From: David Pickford [REDACTED]
Sent: 28 August 2019 15:32
To: Anita Gardner <Anita.Gardner@arun.gov.uk>
Subject: RE: 22 Beach Road, Littlehampton.

From: Scott Castle [REDACTED]
Sent: 23 August 2019 16:19
To: carol.reynolds@arun.gov.uk
Cc: Darren Godfrey
Subject: 22 Beach Road, Littlehampton.
Importance: High

I write further to the client providing me with your feedback on the AASL acoustic report dated 6th June 2019 for the above site.

Figure 4. Internal Measurement Positions

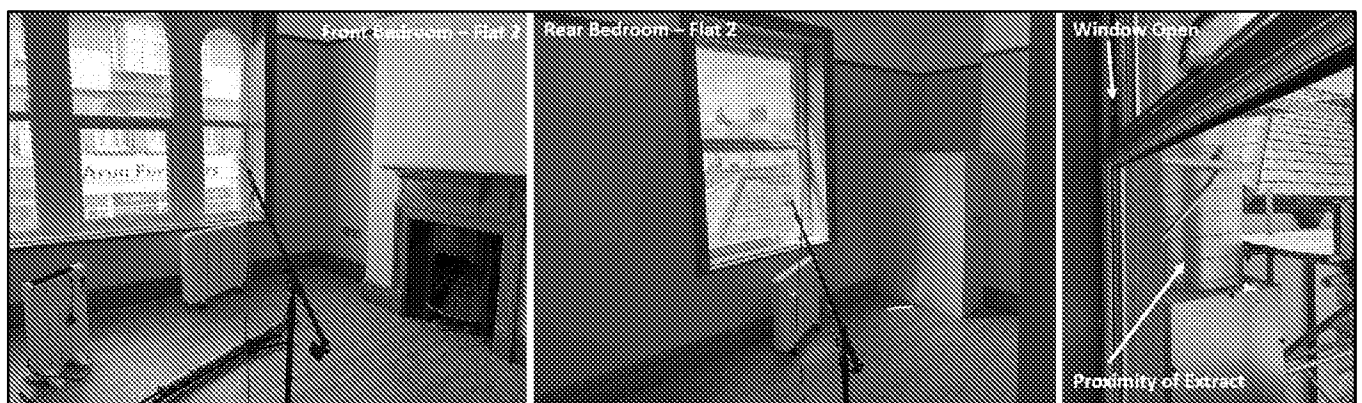
The reverberation times were measured in each of the locations where the surveys were undertaken. As noted from Table 3 in the report, the front bedroom in flat 2, was considerably higher in terms of reverberation than the smaller two bedrooms measured. As per Figure 4 of the report, the image displayed on the left hand side shows the laminated floor already laid.

When the bedroom is lived in and furnished with curtains, beds, pillows and duvets etc, the reverberation time will inevitably decrease and in this case a final reverberation time of 0.5s as was used in the calculations (This is what the Building Regulations state will be the average reverberation time for a furnished room). In this instance the correction used was 3dB as the empty surveyed rooms had an average reverberation time of 1s

Figure 7. Review of 1-hour periods inside Flat 1 bedroom

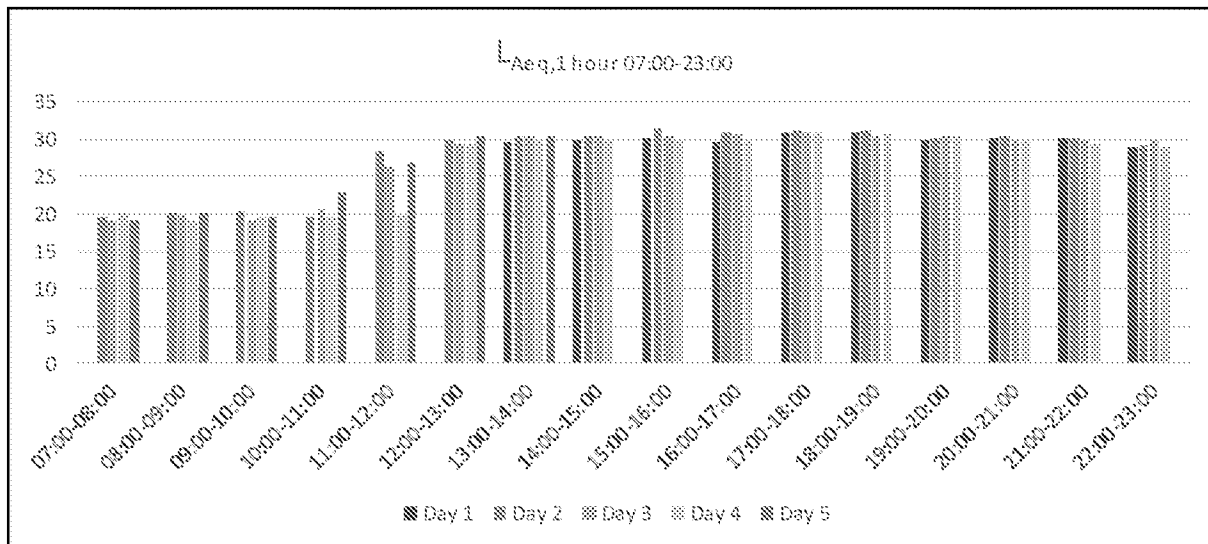
Figures 6 and 7 in the report relate to Flat 1, however the references to 39 and 44dB relate to Flat 2, front bedroom, which is reported in Figure 10.
